Our Ref: 21/0731/FUL

INVALID APPLICATION

PROPOSAL: ERECTION OF SHEEP SHED
LOCATION: East Roucan, Torthorwald, Dumfries, DG1 3QE

Front View - Mostly open

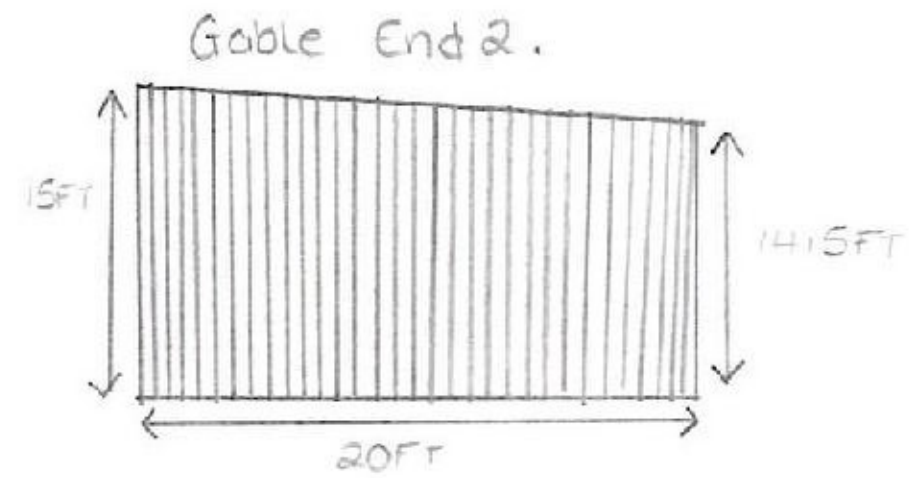
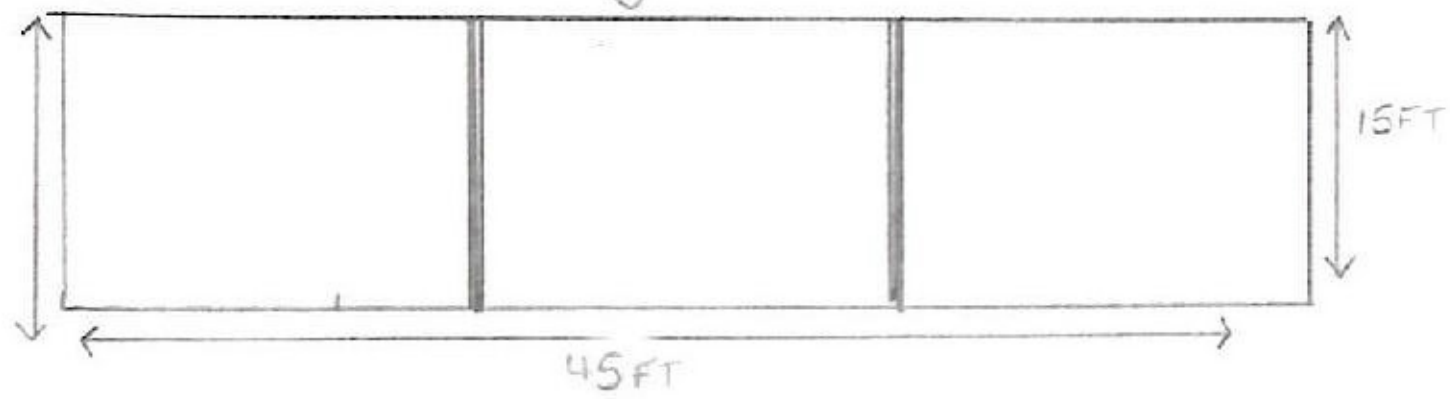
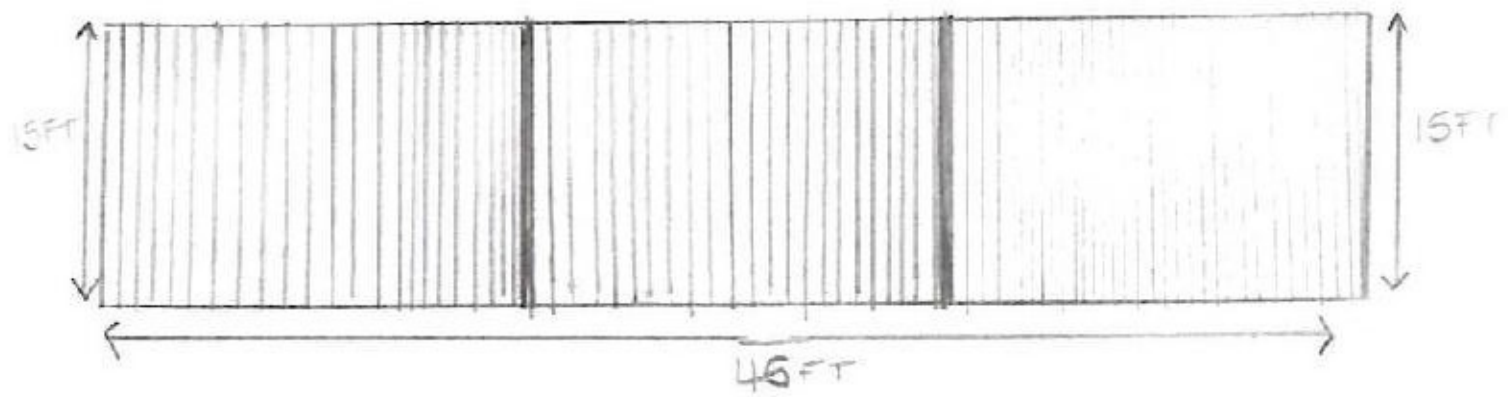
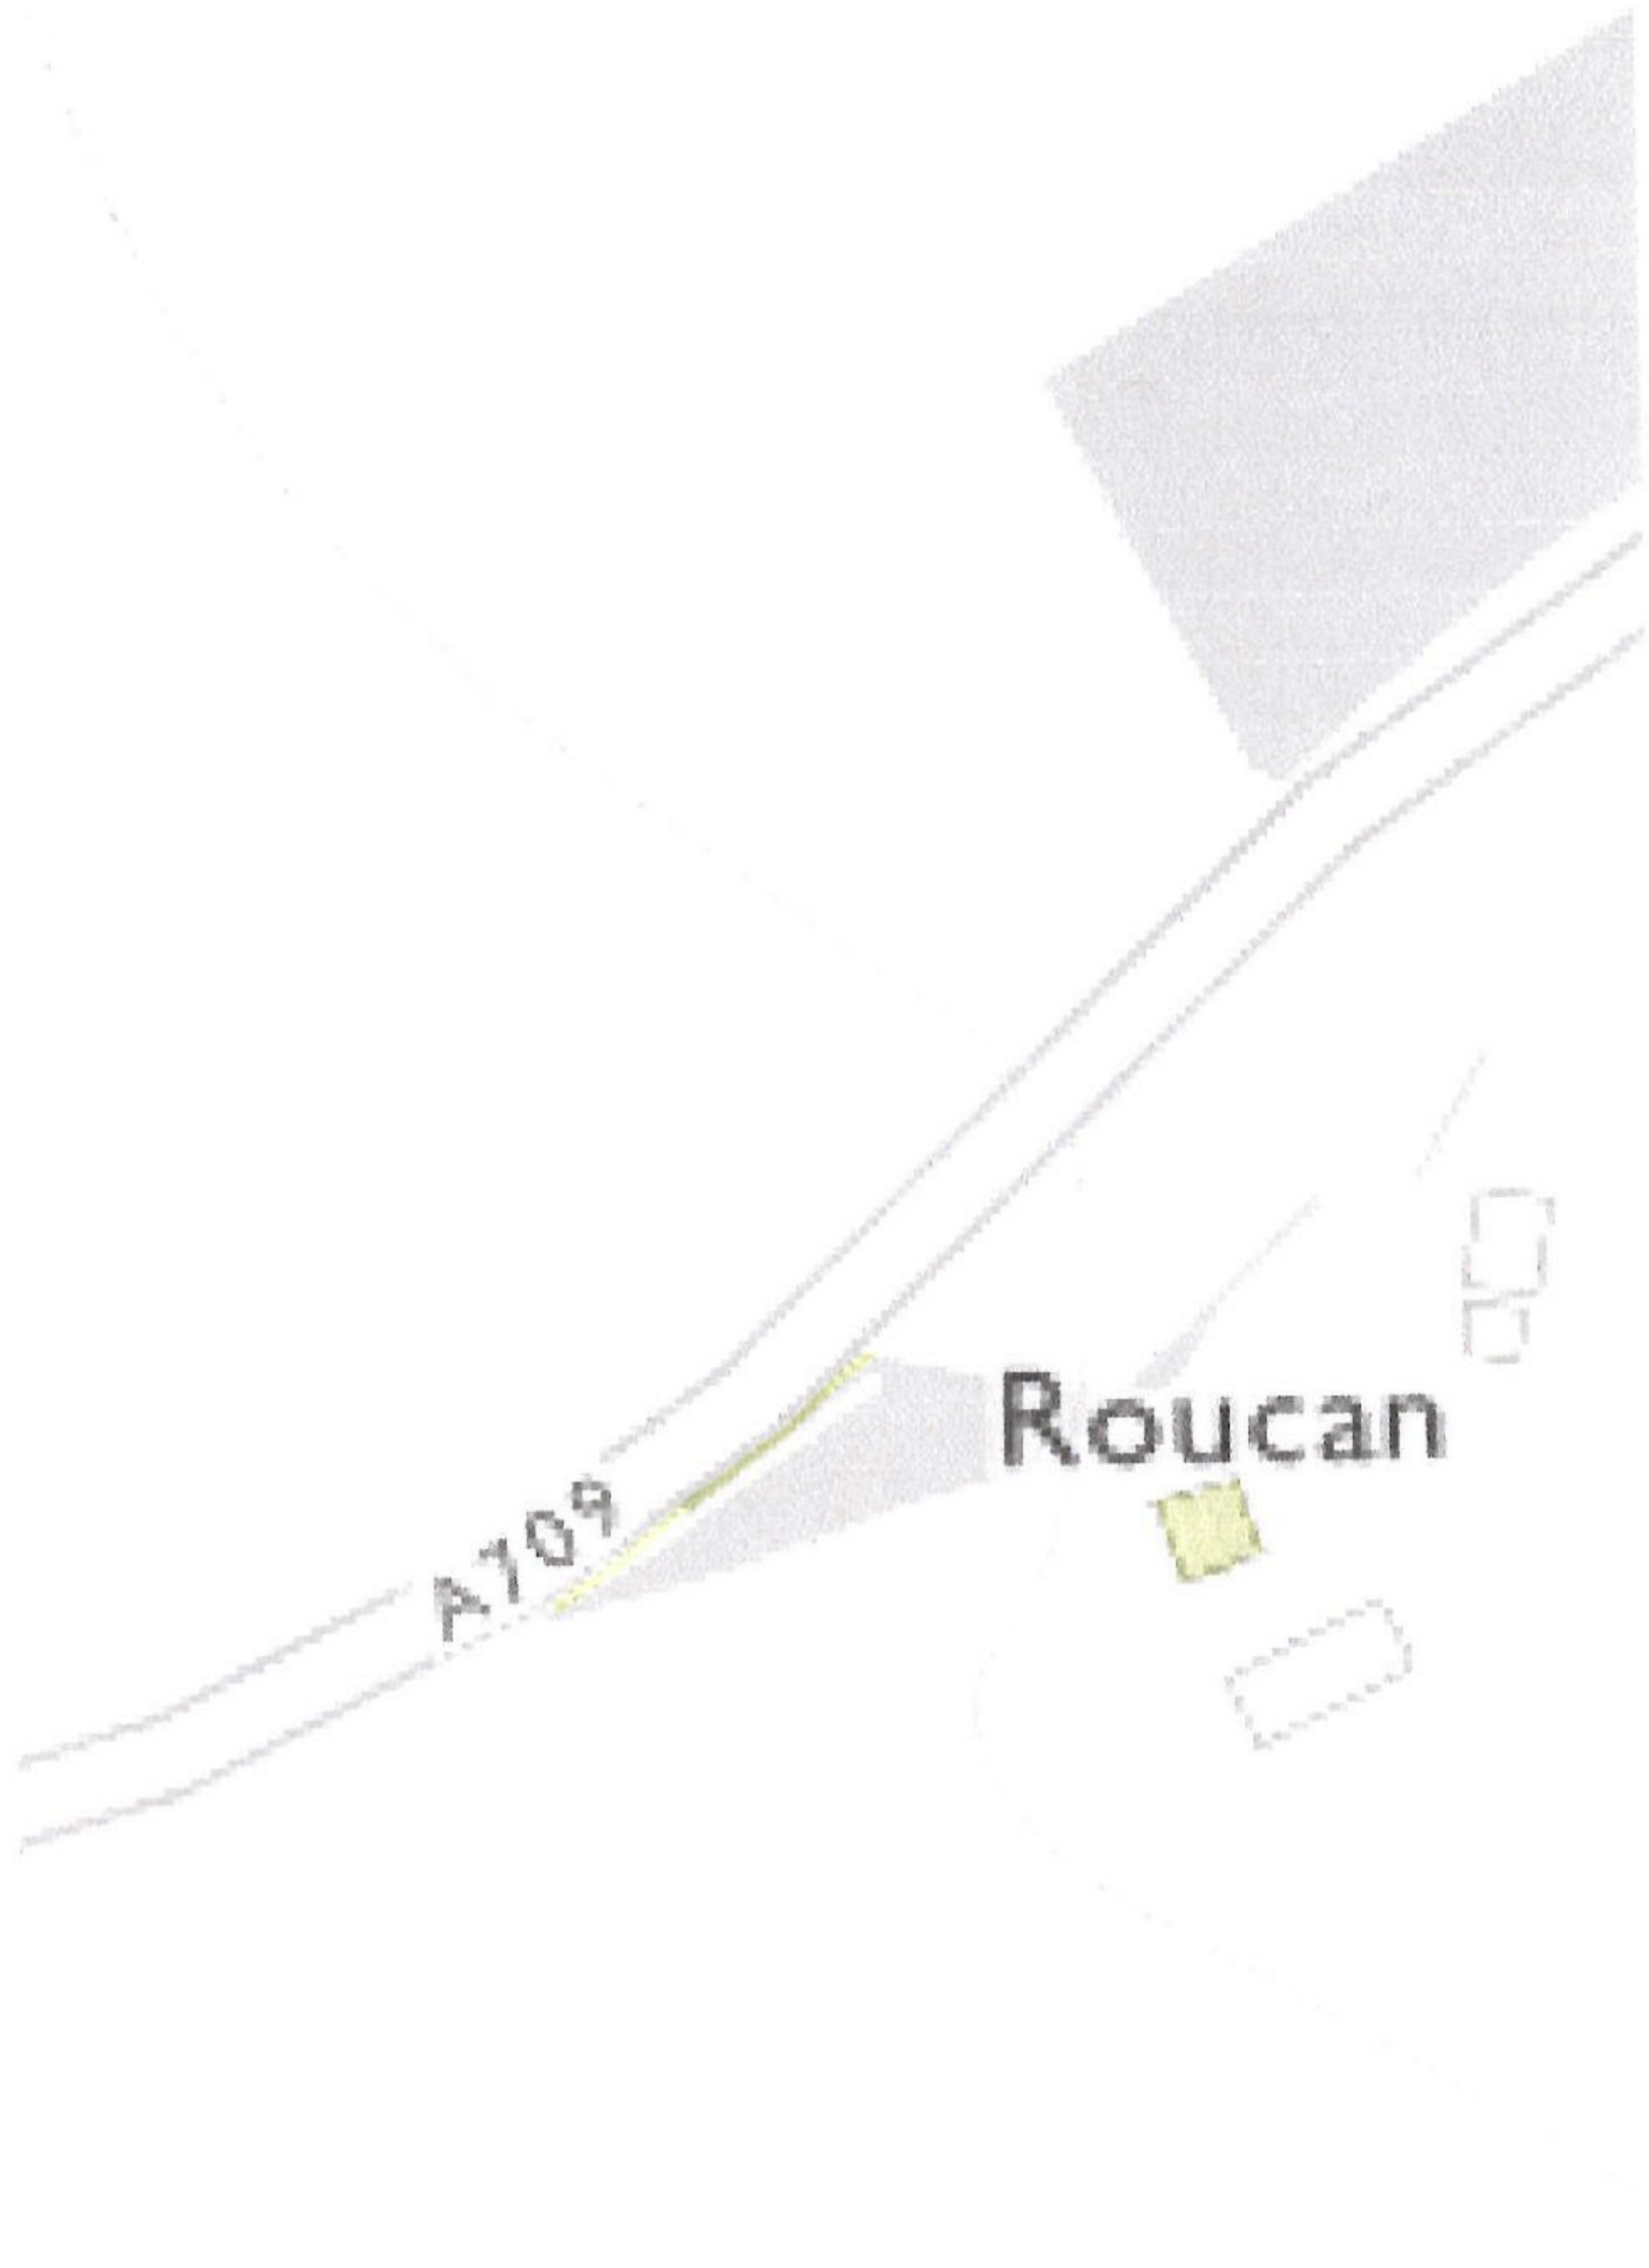
- 01. Please forward a block plan for the application site at a scale of either 1:200 or 1:500, showing the position of the proposed shed.**
- 02. Please submit amended drawings of the proposed shed, drawn to a metric scale of 1:50 or 1:100, and annotated in metres. Please include a floor plan.**
- 03. Please submit an amended location plan outlining the area of the proposed shed in red and all other land under control of the applicant in blue.**
